2 March 2018

Your reference: SSD 8900
L. Tchan
54 Greenway Drive
West Hoxton NSW 2171

**STATE SIGNIFICANT DEVELOPMENT APPLICATION – NULON MOTOR OILS FACILITY
(SSD 17_8900)
BRINGELLY ROAD BUSINESS HUB, LEPPINGTON (PART OF LOT 10 DP 29104)**

DRAWING TITLE
SITE PLAN

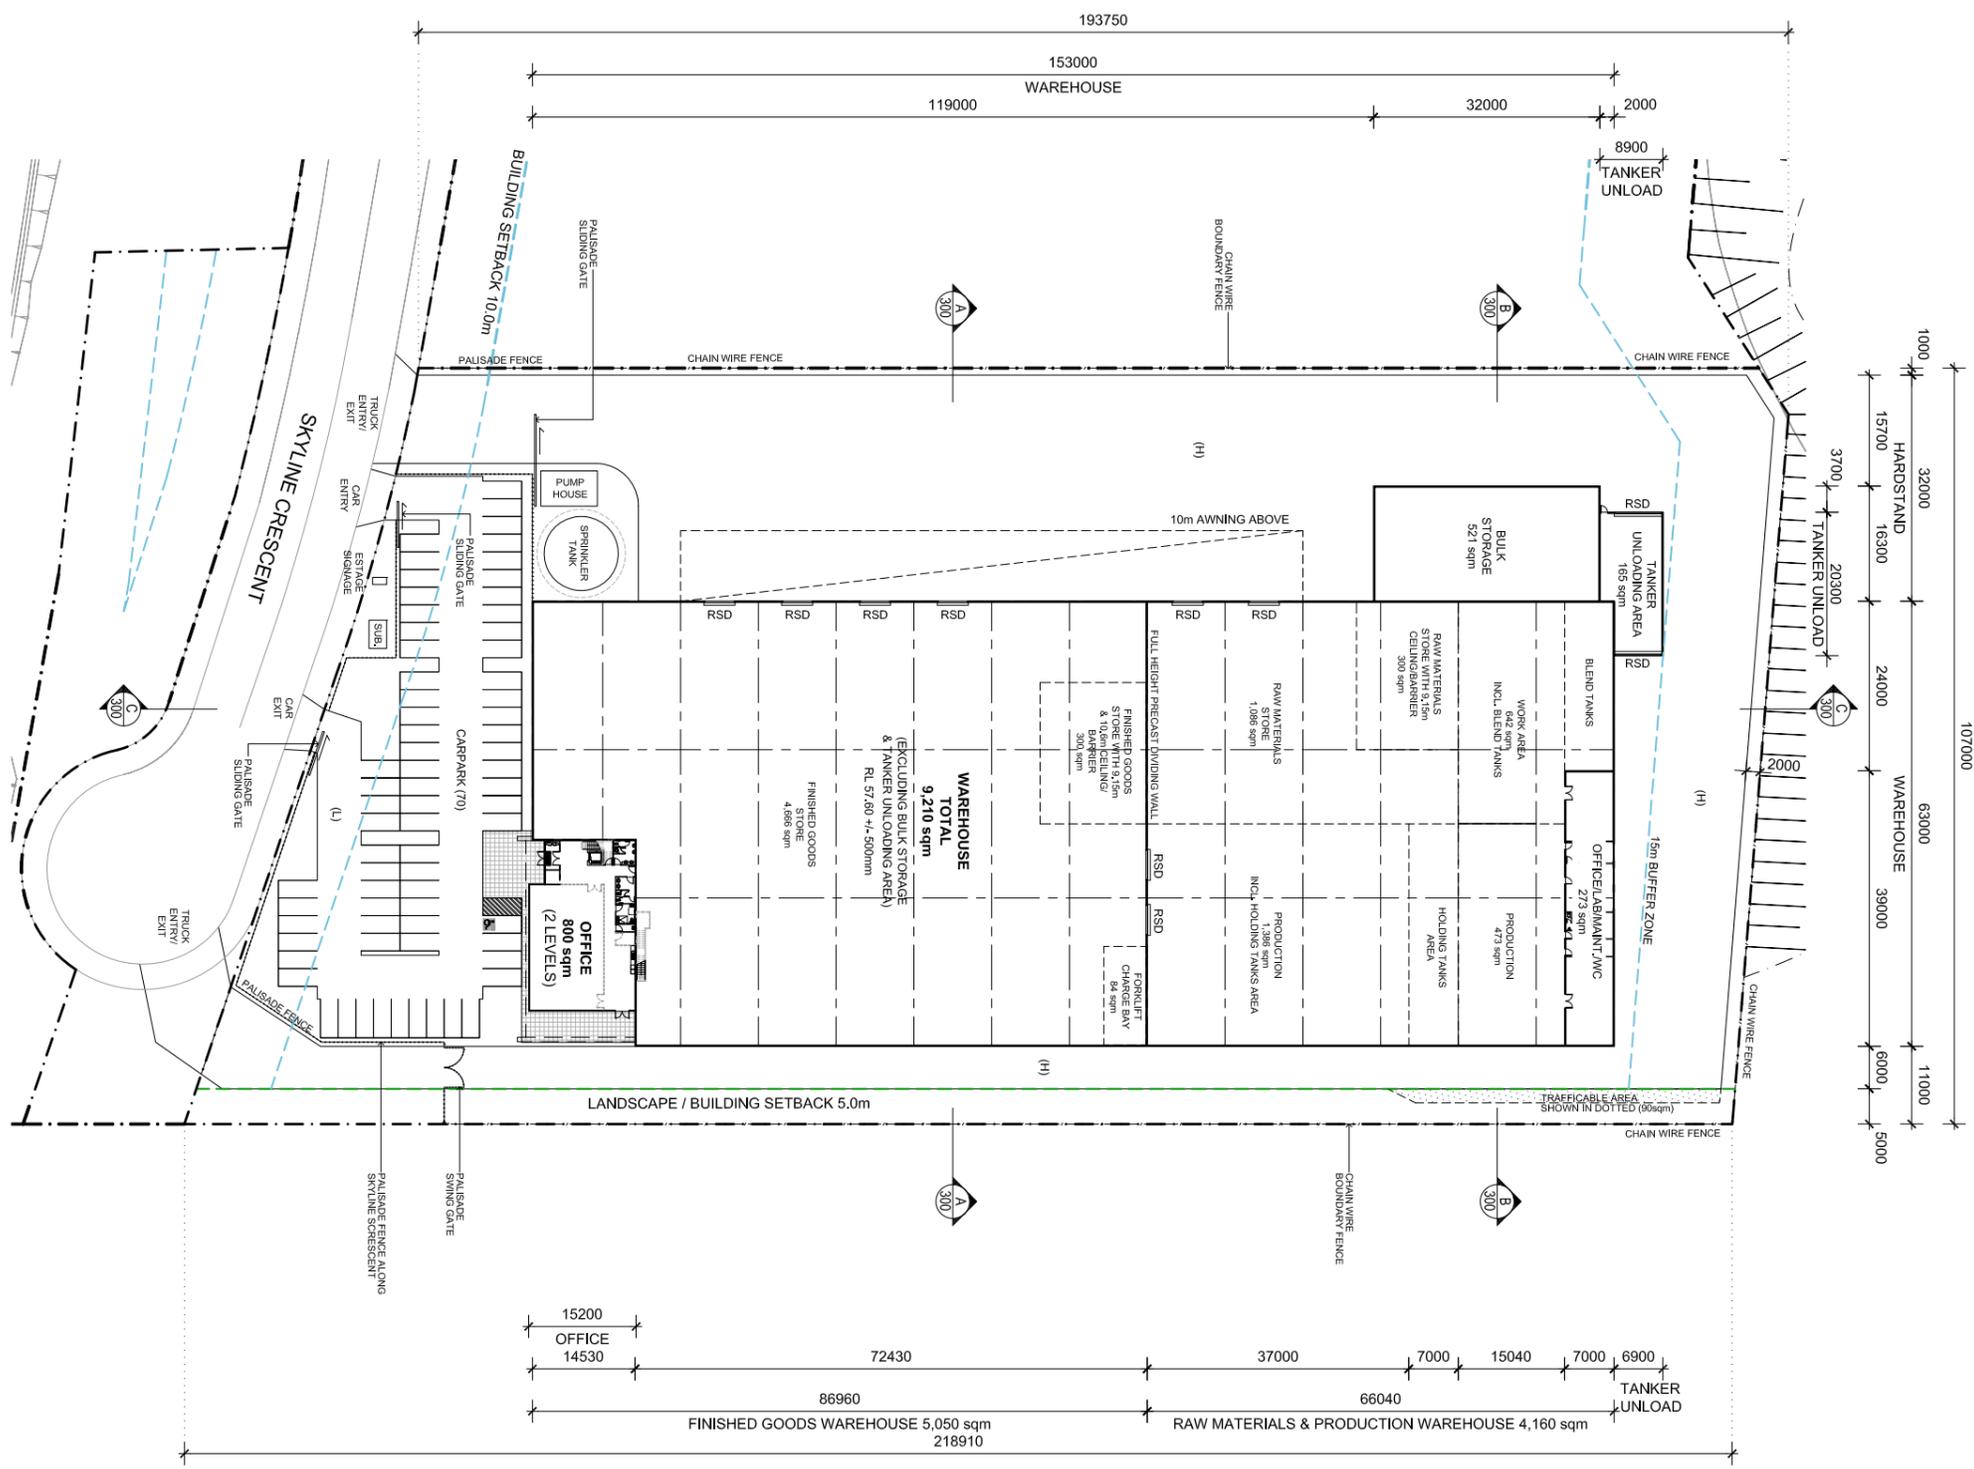
6. The site plan submitted with the application is considered to be poor, lacking basic details and provides no context of surrounding residential properties. It shows the proposal as an island, but the site is adjoined by established residential properties to the east on the opposite side of Cowpasture Road and residential properties to the north. In fact, there is a residential dwelling located to the immediate east of the site on the corner of Cowpasture Road and Bringelly Road. It is highly inappropriate and irresponsible for a State Significant Development industrial development involving the preparation and manufacturing of highly flammable motor oils to have little regard to sensitive land uses surrounding the site.

It is noted that the site is located roughly 200 metres from the residents of Horningsea Park and within 450 metres of the residents of West Hoxton. Within West Hoxton, along Stuart Road is an existing child care centre. It is further noted that the site is situated less than 1.2 kilometres to the east of the Upper Canal Sydney Water drinking water catchment. The Upper Canal is an open canal supplying precious drinking water to the residents of Western Sydney.
